Re: HVO Continuation Project (SSD-11826681 and SSD-11826621)

HVO Continuation Project – Response to EPA request
for additional information relating to noise

Subject: HVO Continuation Project - EPA comments on Response to Submissions relating to noise

HVO Continuation Project – Response to EPA request
for additional information relating to air quality

Figure 1 Sensitive receptors

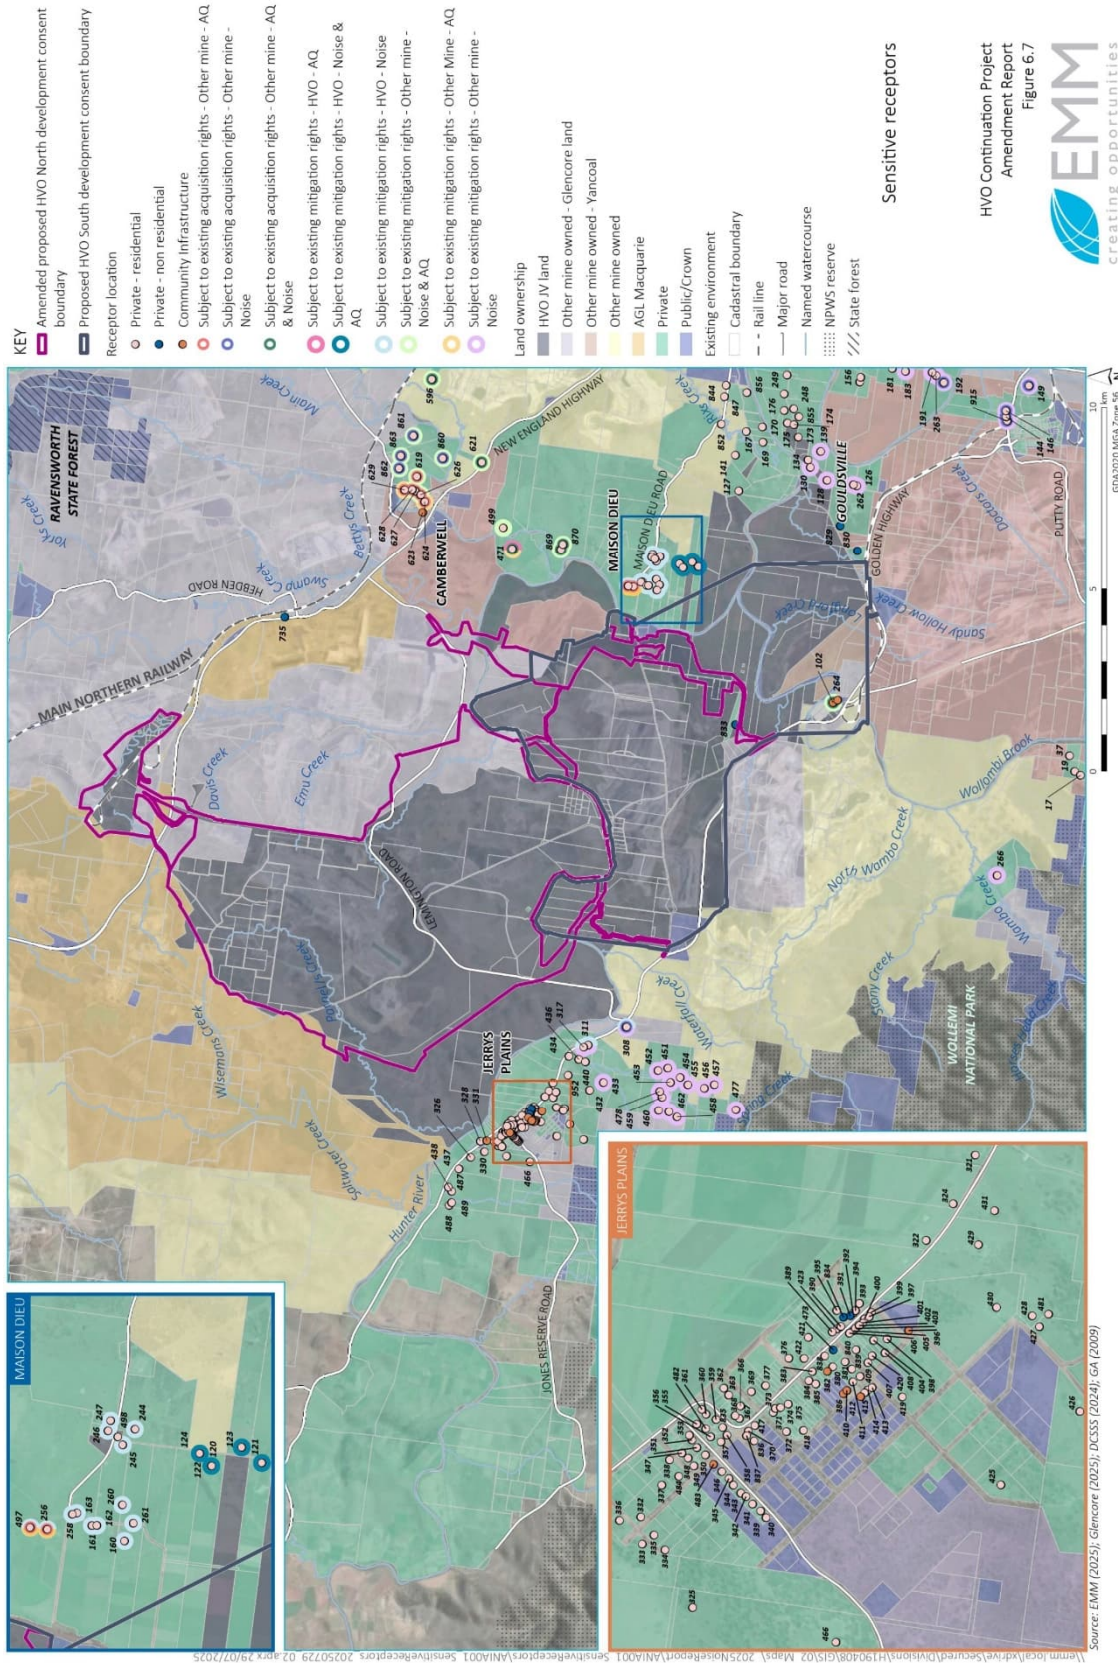
1a) A list of receptors ranked by the highest predicted cumulative impacts and predicted incremental impacts for all modelling scenarios included in the original Air Quality Impact Assessment (AQIA).

The requested lists of receptors have been presented graphically in Figure 1 showing the top 5 receptors based on Project increment, the top 5 receptors based on cumulative concentrations, or where the modelling indicates more than 5 days above the 24-hour average PM₁₀ assessment criterion. In some cases (e.g. 596) the receptors do not appear on Figure 1 as they are at significant distances from HVO and the air quality outcomes were primarily influenced by other mining operations.

- Based on incremental impacts from the Project (shown labelled in blue in Figure 1):
 - Receptors 326, 327, 328 and 437 are private sensitive receptors in Jerrys Plains, that are not subject to any acquisition rights.
